# CITY OF ALBUQUERQUE

September 24, 2024

**RE: Retail at Bar 7**  
**Conceptual Grading Plan and Conceptual Drainage Report**  
**Engineer's Stamp Date: 04/08/2024**  
**Hydrology File: B14D010D**

DATE 09-25-24
DRAWING 2023004-CR
SHEET # 8
DATE 09-25-24
SCALE 1"=40'
PROJECT 5571 MIDWAY PARK PL, NE ALBUQUERQUE, NM 87109 (505) 854-7100
DESIGNER TIERREA WEST LLC
WWW www.tierrewestllc.com

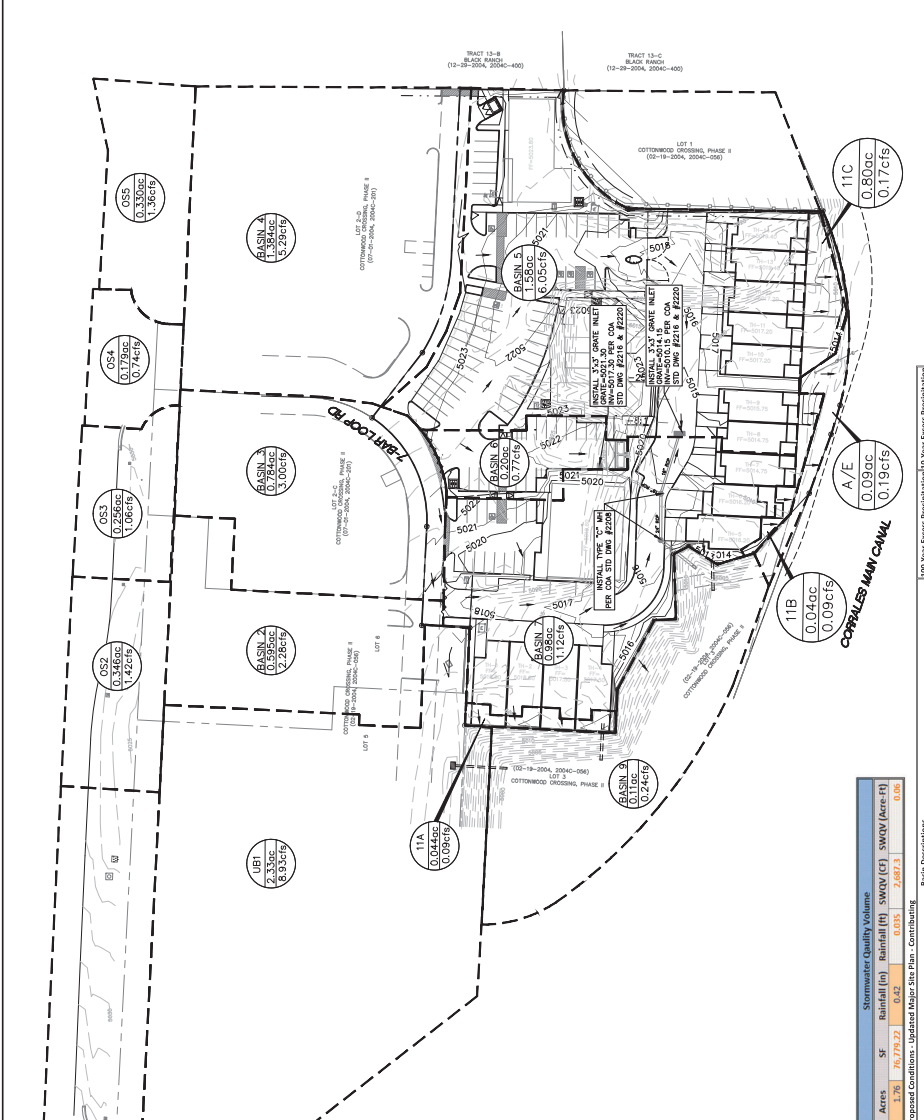
2. Townhomes 1-4 show Finished Floor (FF) elevations equal to adjacent Top of Wall (TW) elevations which conflicts with Section A-A on Sheet EX-1, Cross Sections at Pond and at Channel, that show Pad Elevations equal to adjacent Proposed Top of Walls. Clarification / correction should be provided.

3. Townhomes 1-4 show walls extending to the back existing wall, are wall extensions to be provided for Townhomes 5-14? This may affect the ponding behind Townhomes 5-14.

4. The earthen fill materials proposed for the small retention basins at the backs of the Townhomes should be considered and identified to confirm application of intended uses.

5. Please show Cross Lot Drainage Easements if needed on the Grading & Drainage Plan specifying the beneficiary and a maintenance agreement.
6. The spot elevations shown at the middle entrance to the development appear to conflict with the delineated drainage basin boundaries in the Conceptual Drainage Report.

7. The spot elevations shown at the southern area of Building B appear to conflict with the delineated drainage basin boundaries in the Conceptual Drainage Report.
